Comment to planning proposal ref: PO/12/21/L

30 November 2021

From Mr C Richards & Mrs J Prewett

We reside at Slate Cottage, the property immediately adjacent (north west) of the proposal site, St John's Cottage.

PROJECT: ST JOHNS COTTAGE POLING STREET, POLING			
DRG TITLE: PROPOSED ELEVATIONS			
JOB NO:	DRG NO: 1300		
SCALE @ A1: 1:50 @ A1	DRN BY: M.SKINNER		
DATE: 06/2021	CKD BY:

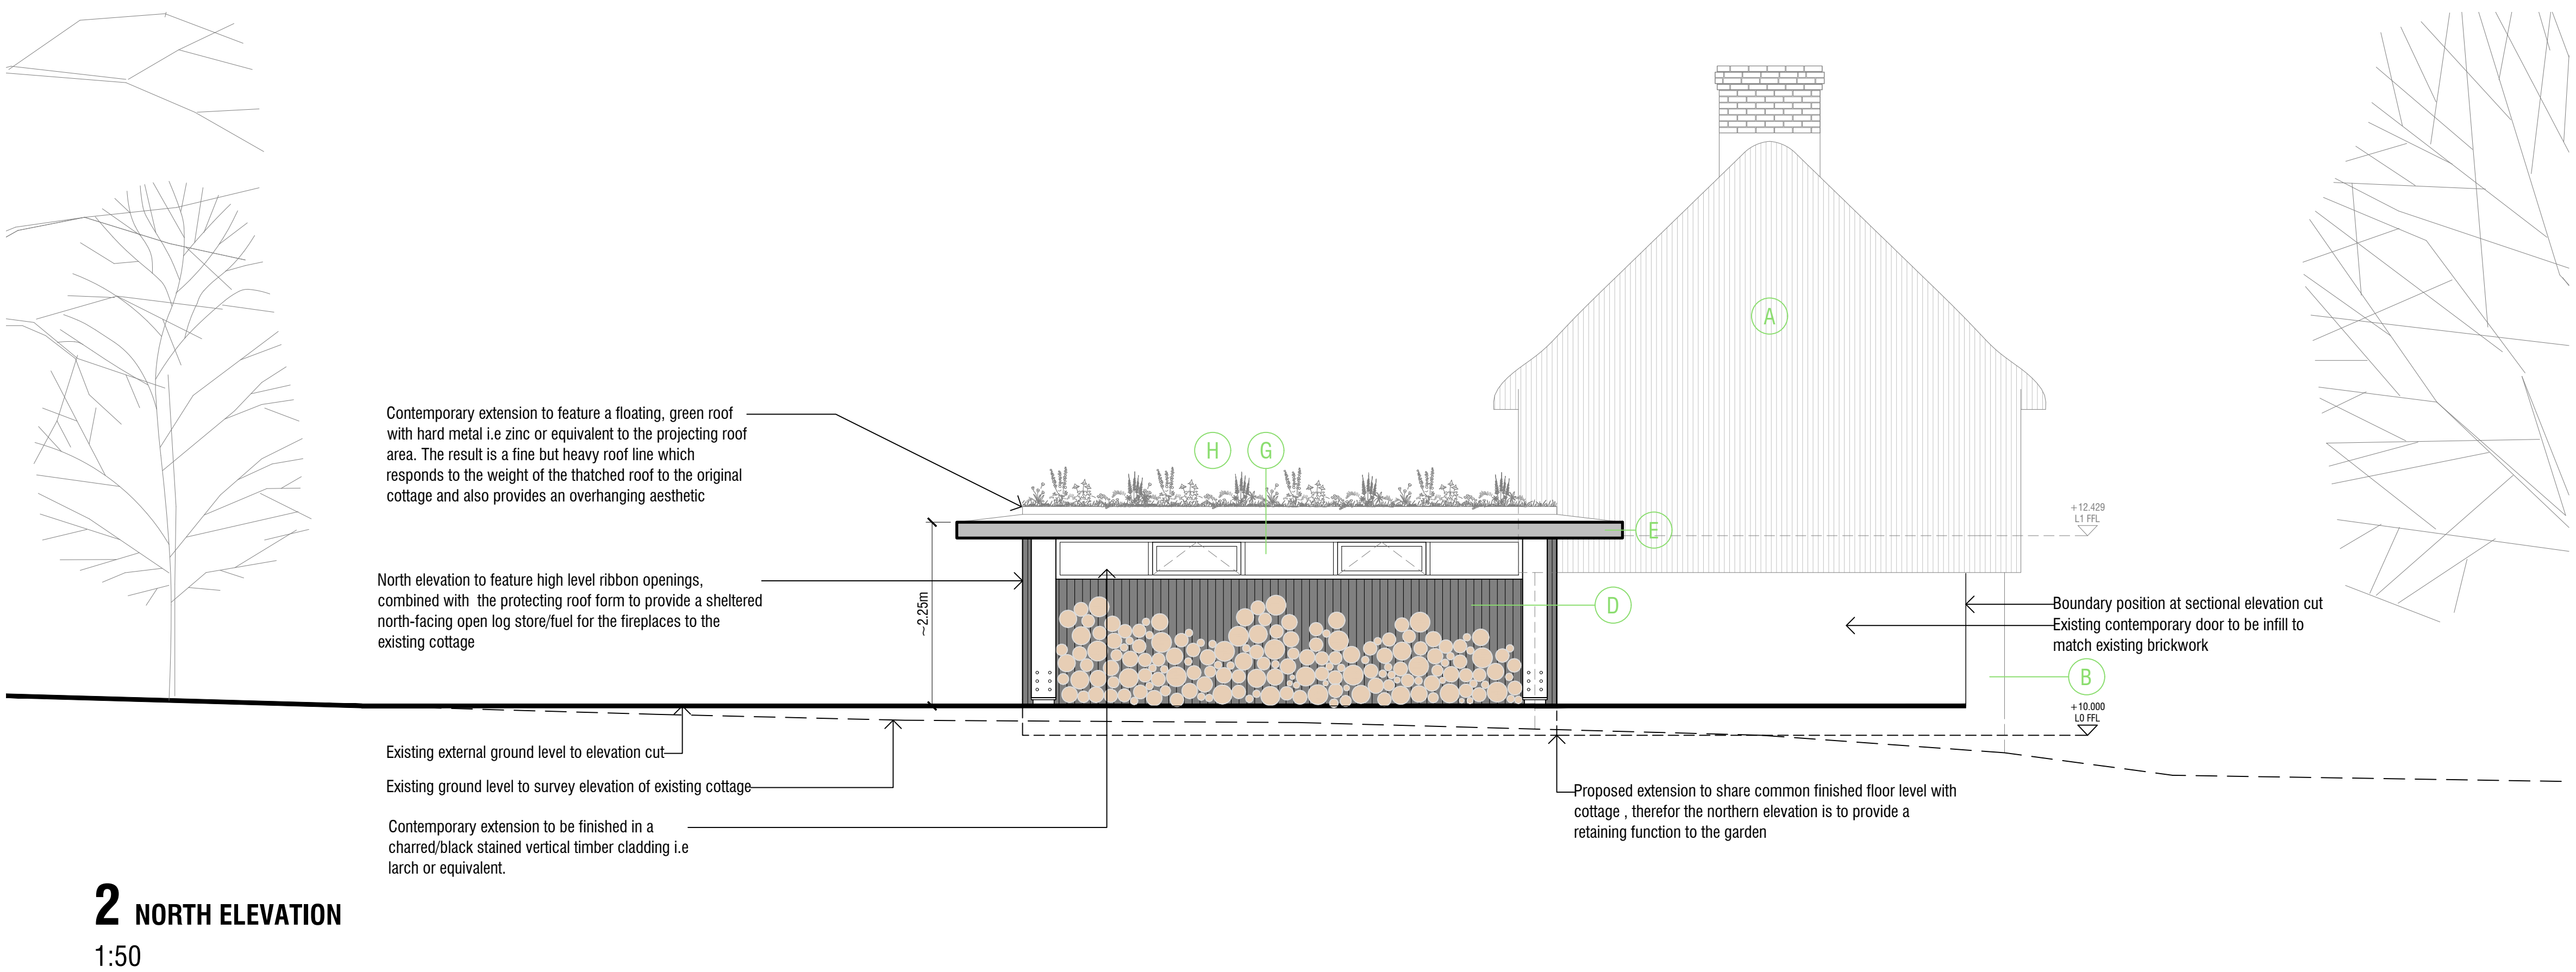
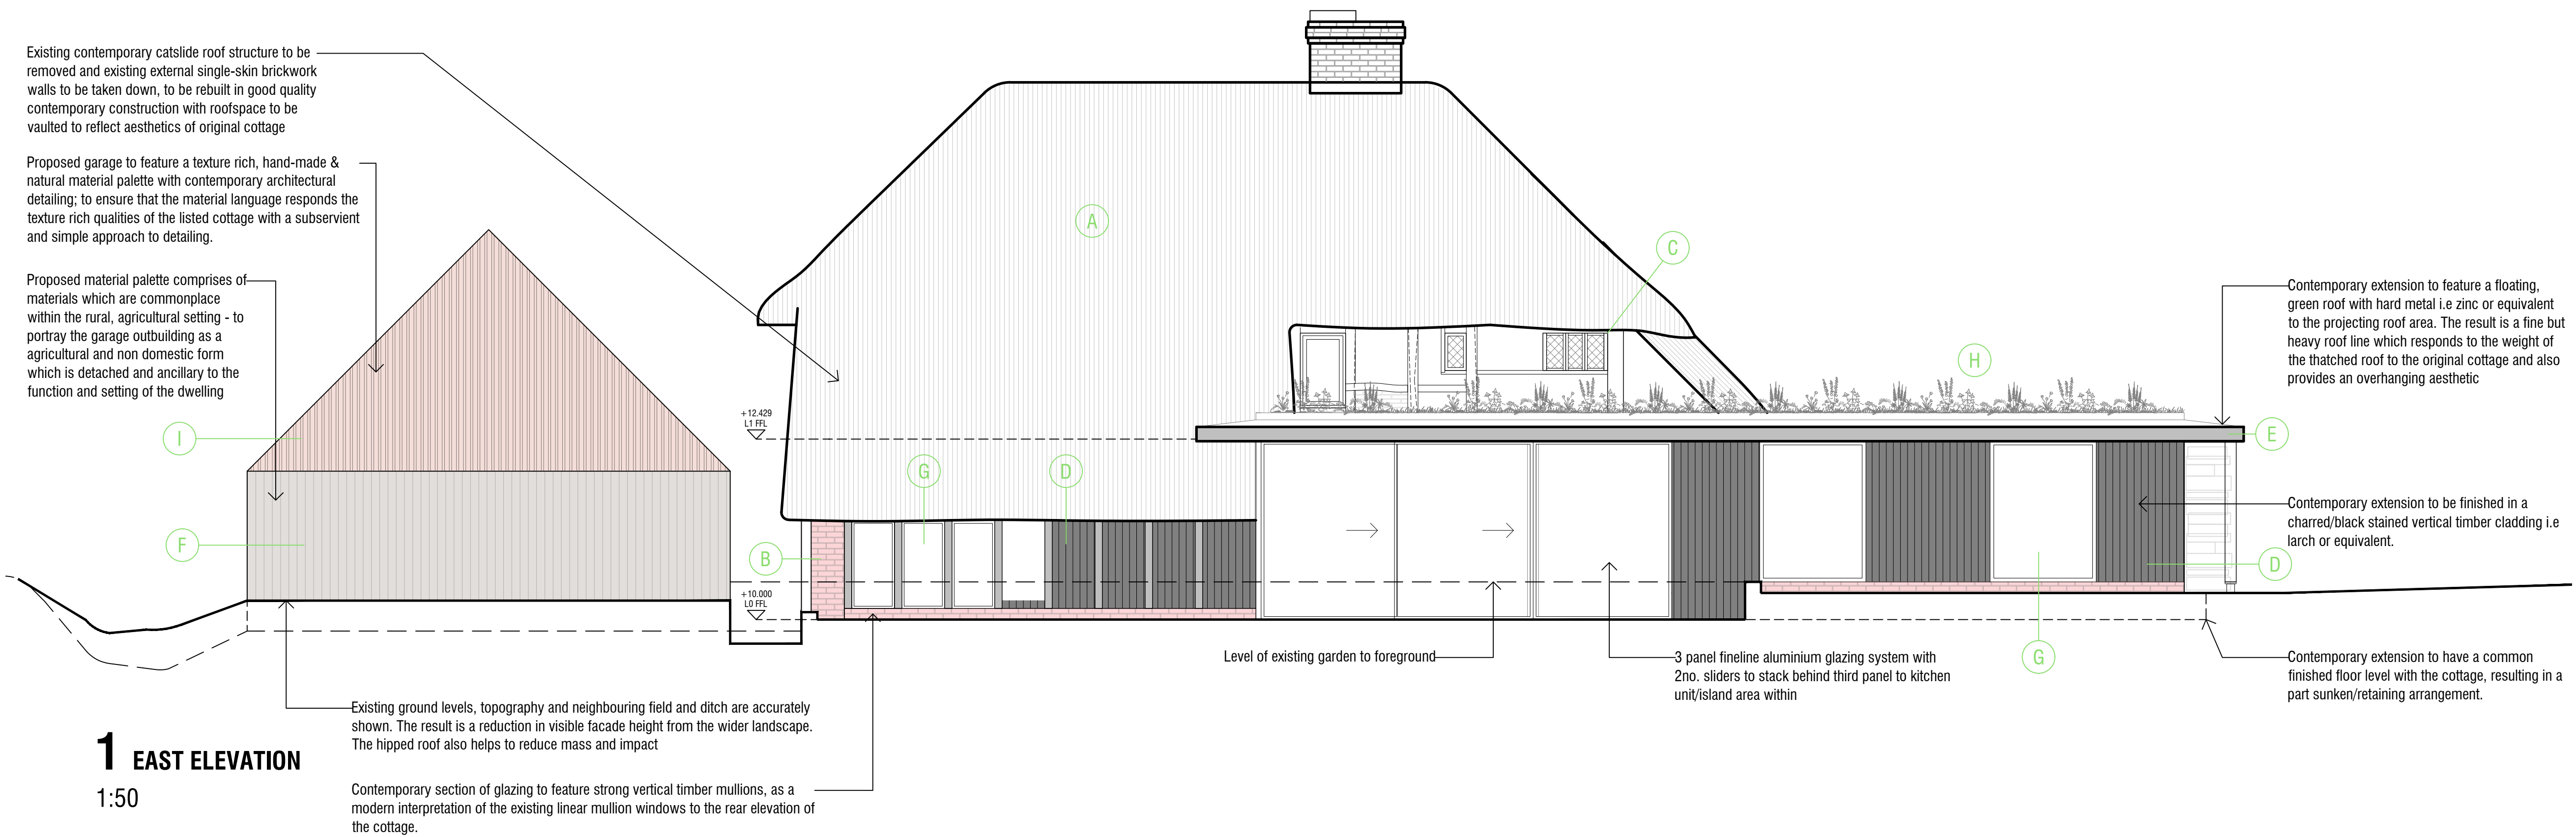
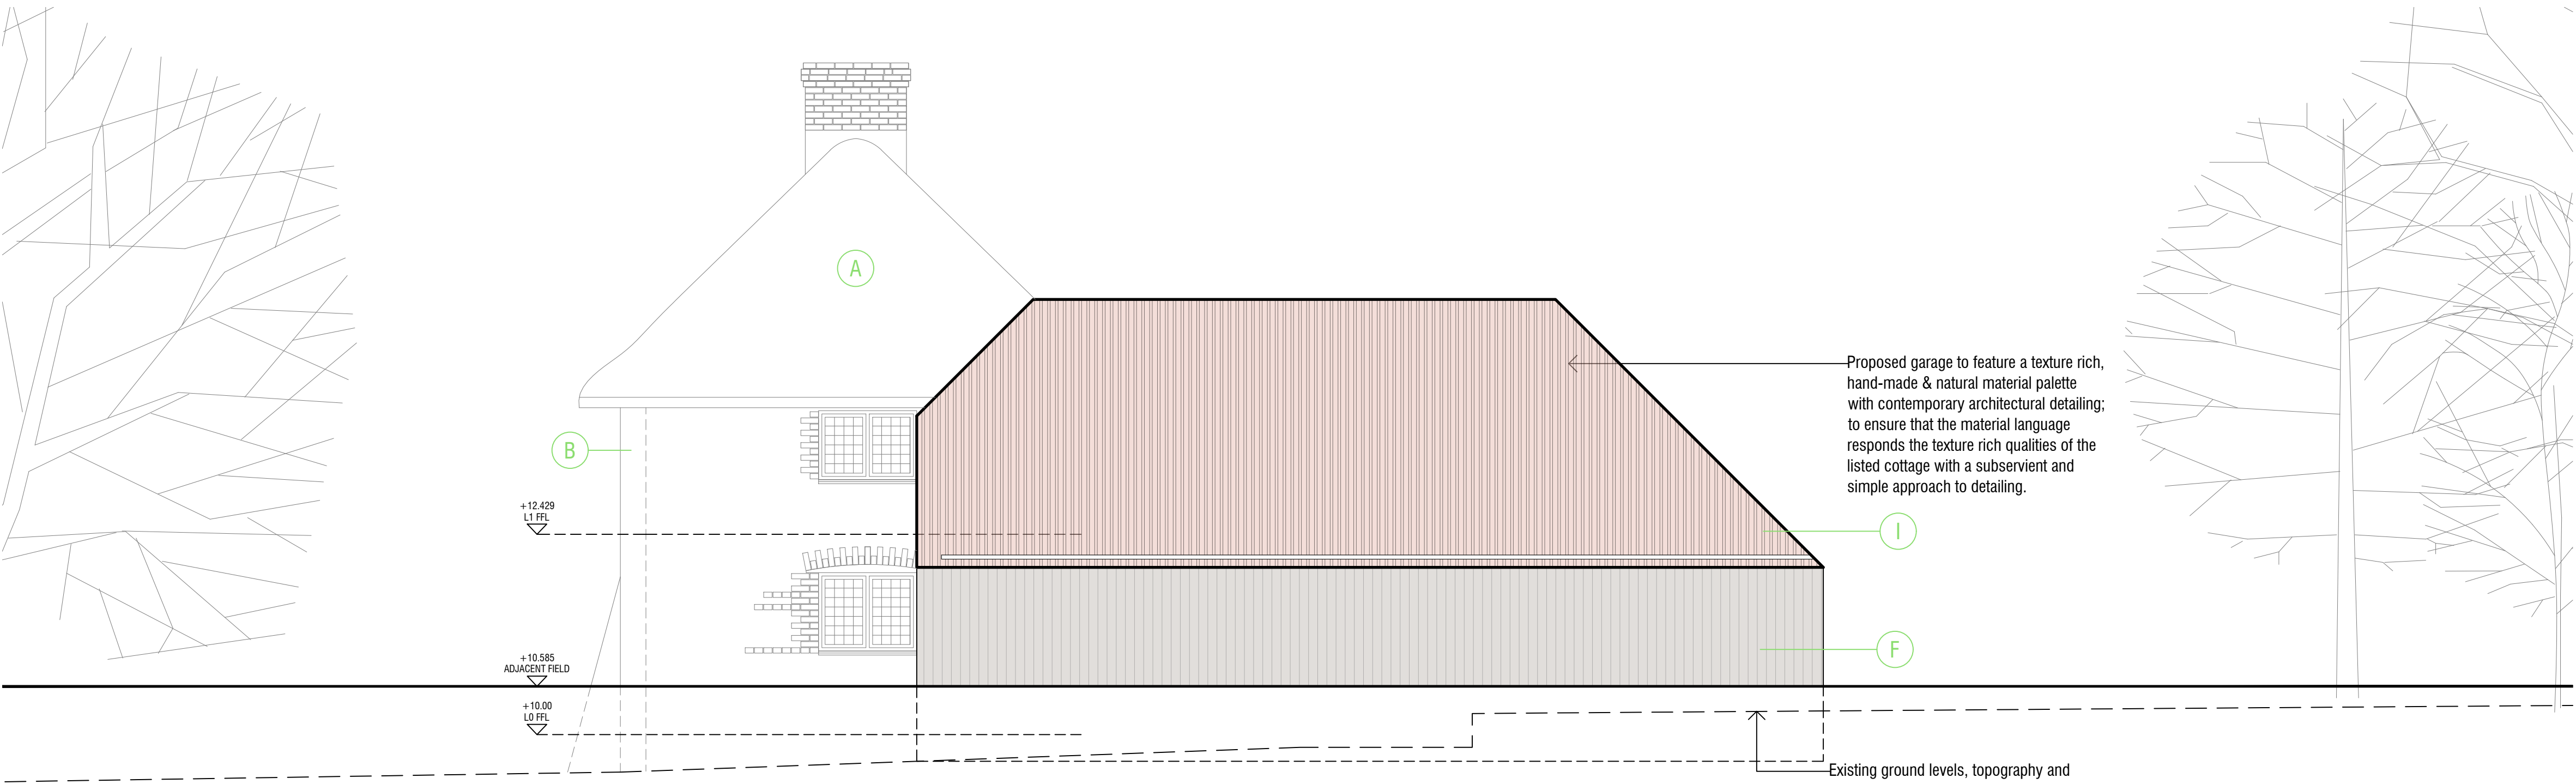
Taken at face value and without due reference to the proposal being a Grade II listed Heritage asset, (and without reference to 1-3 above) the proposal seeks to increase the built form of the current dwelling and its associated extensions and outbuildings by an amount that dwarf and dominate the original Listed Heritage Asset. The proposed garage building alone equates to a built form that is comparable in its overall mass to a small chalet bungalow and comparable to the footprint of the original Listed Cottage. It appears as an alien form in this setting when viewed against the Heritage Asset.

For these reasons it is difficult to see how the proposed mass of both the Garage building and the side/rear extension can be viewed as subservient to the existing Heritage Asset.
